**Case Officer:** Lewis Knox

**Proposal:** Conversion of existing outbuilding to living accommodation with pitched roof; single storey extension to connect to existing property; conversion of existing carport to garage with pitched roof; change existing flat roof at front of property to a pitched roof to link in with new conversion and garage (amendments to existing approval reference 18/01650/F)

**Application: 18/01650/F**                      Permitted                      23 November 2018

Project Name: ROBIN HILL EXTENSION
Drawing Title: P2-PROPOSED ELEVATIONS
Property Address: ROBIN HILL, BURDROP OX15 5RQ
Drawn By: P.WARD
Scale: 1:100
Last Change Date: 20 MAY 2021

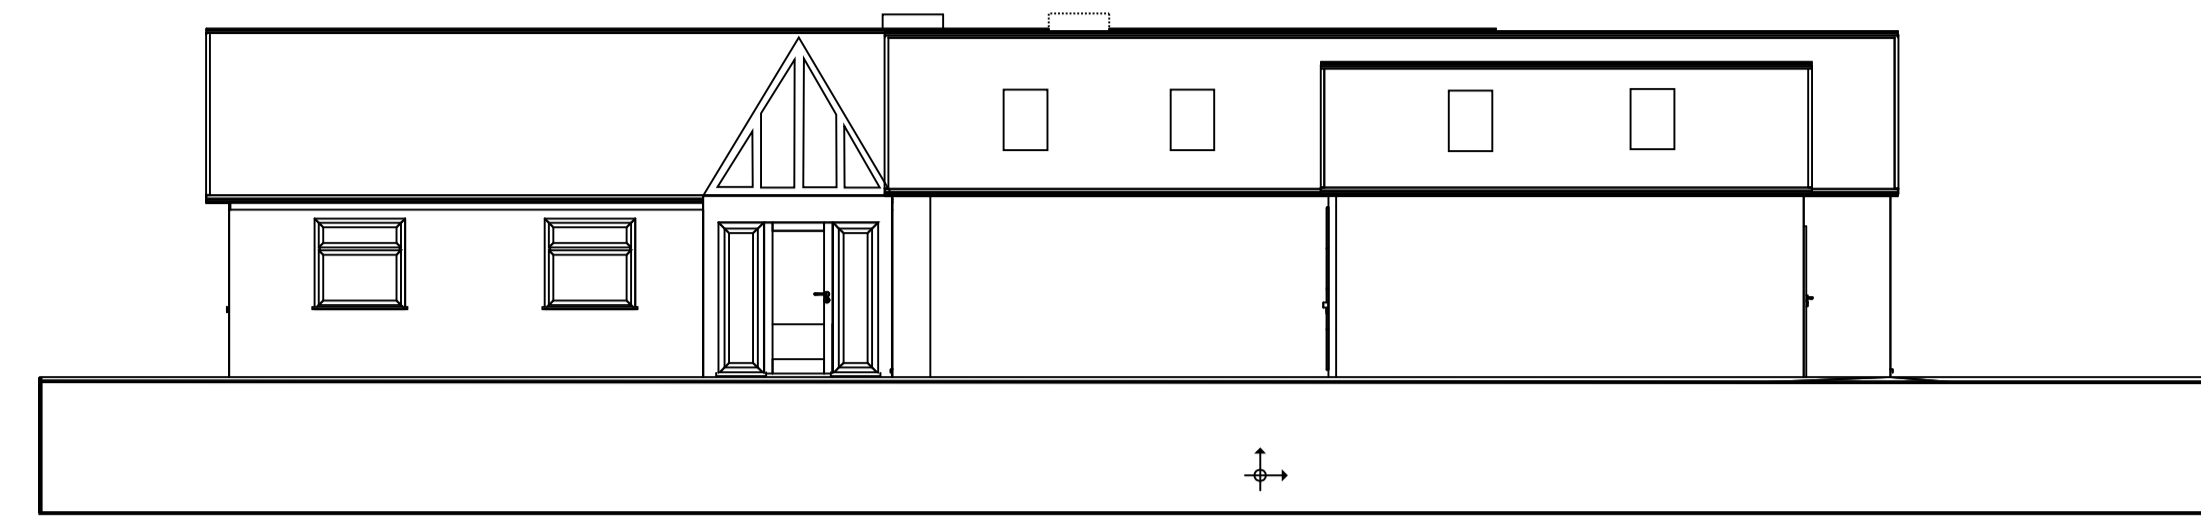
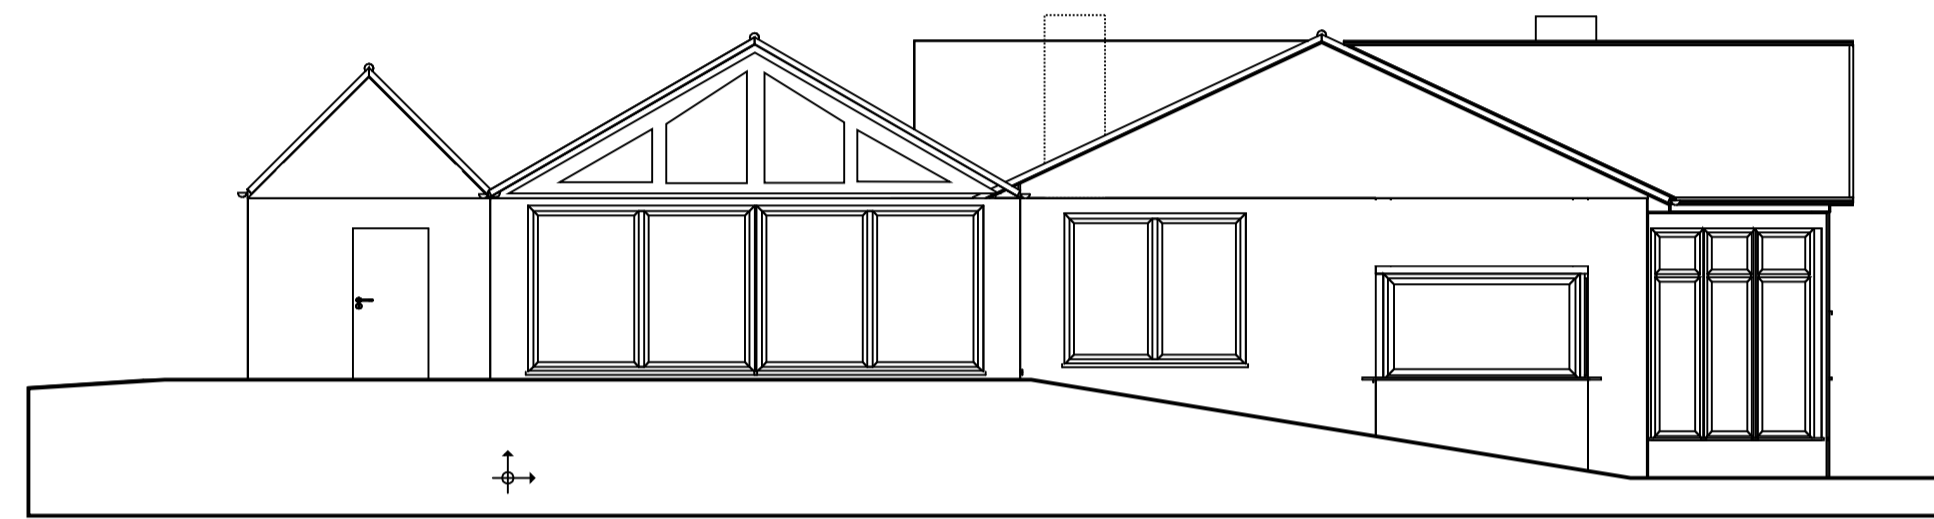
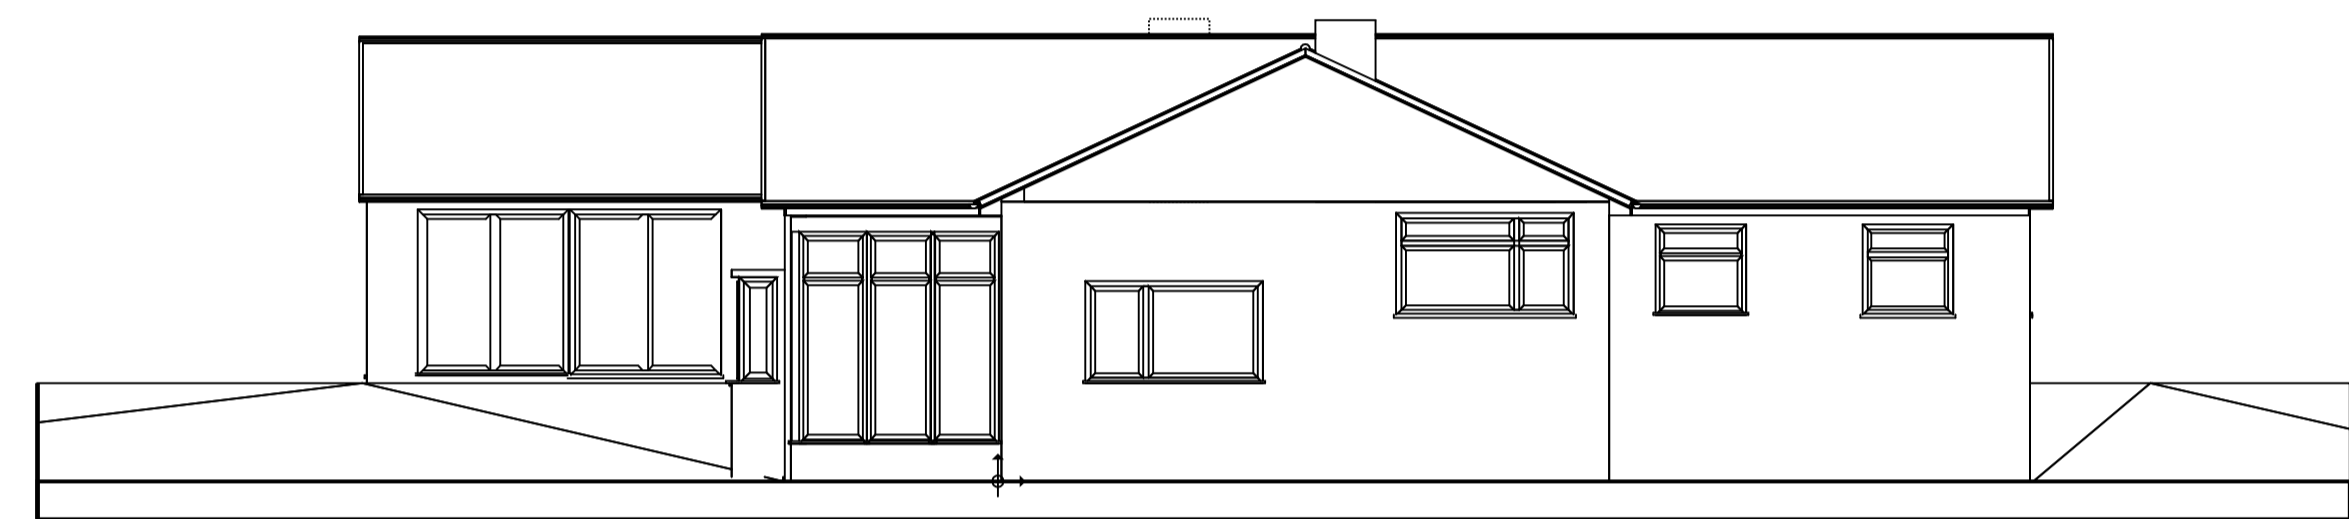
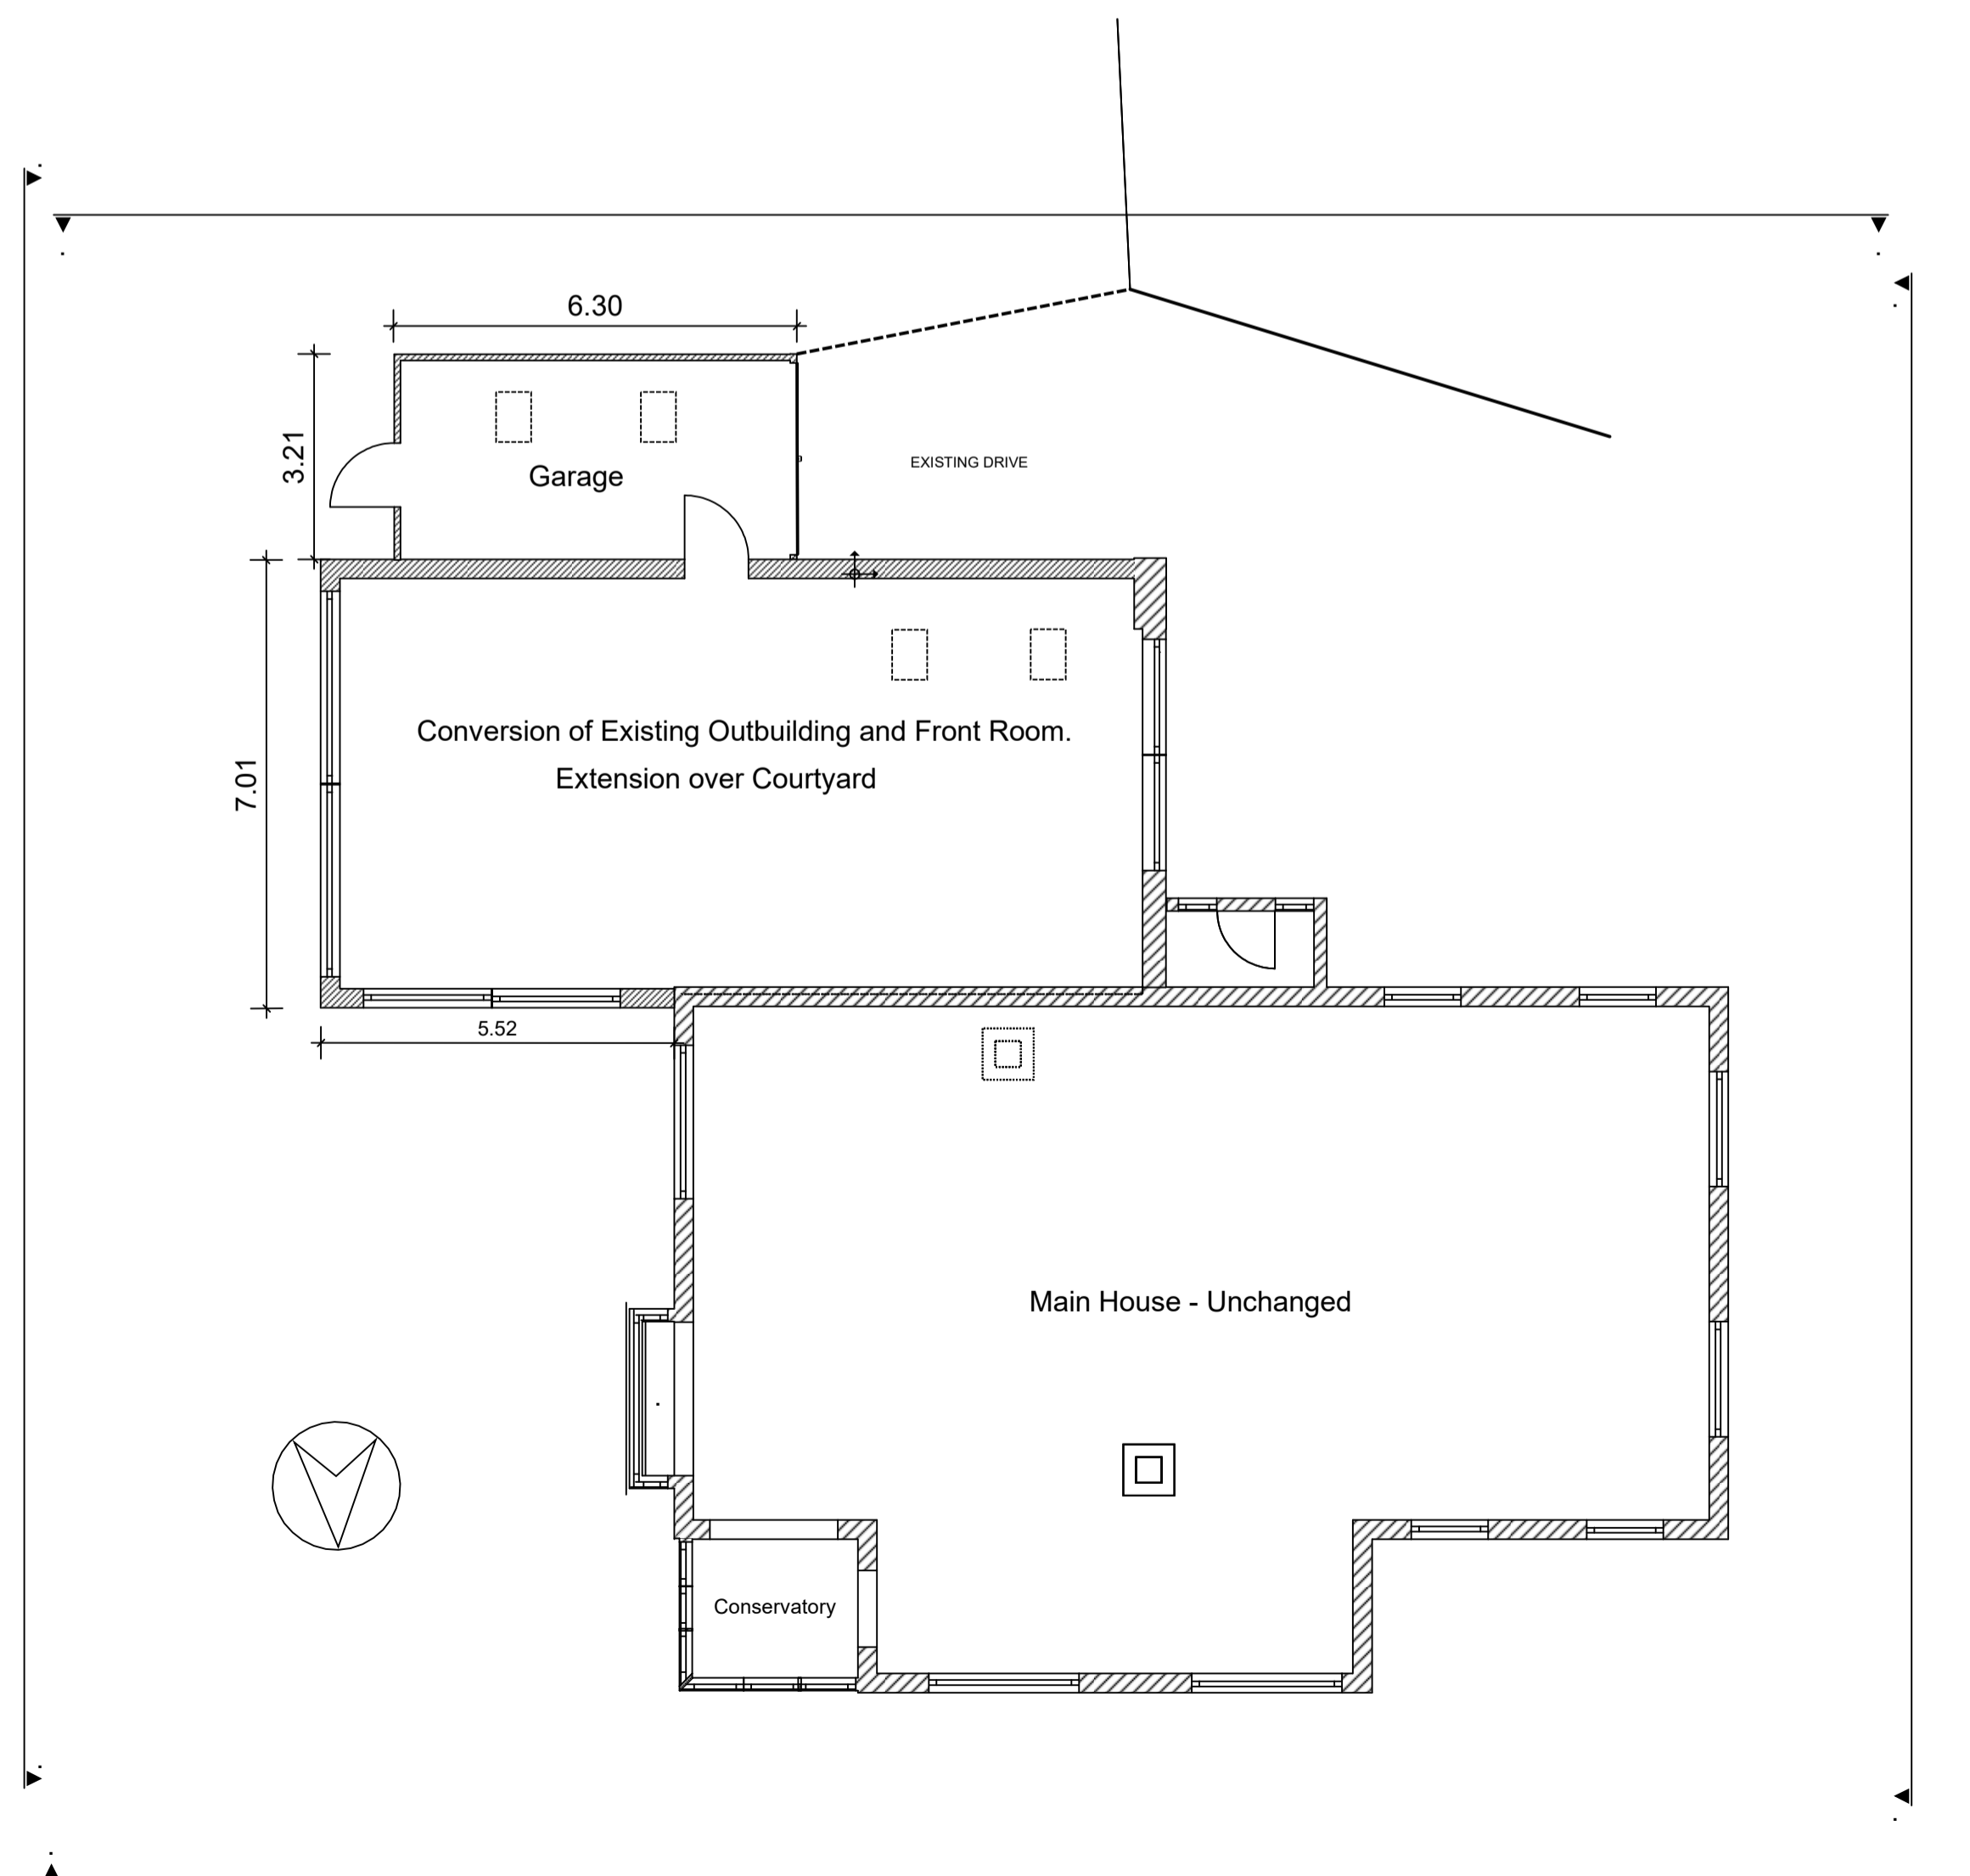
- The main alteration in this proposal beyond what was previously approved in the alterations to the roof pitches to the front of the dwelling. Instead of rotating the roofs so the gables face the front of the site the garage would remain as existing and the roof over the existing flat roof would match this. Given that it would retain the existing character of the site, it is not considered that there would be any harmful impact on the setting of the conservation area as a result of this change.

- Oxfordshire County Council Highways initially raised concerns regarding the ability to manoeuvre a car into and out of the garage due to the building up of the existing car port walls. They raised no objections to the proposals subject to the submission of a swept path analysis of a large vehicle accessing the garage.

- Through discussions between the Highways Officer and the applicant a further document was submitted which made the following changes:
  - Overall garage footprint remains the same

- Garage walls have been changed to single leaf thereby increasing the internal length and width (6.08m x 3.1m)
  - Opening has been increased to improve clearance

- Vehicle used for analysis is 4.6m length
- Following these changes Oxfordshire County Council removed their reservations and as such a further Swept Path Analysis is no longer required through condition.
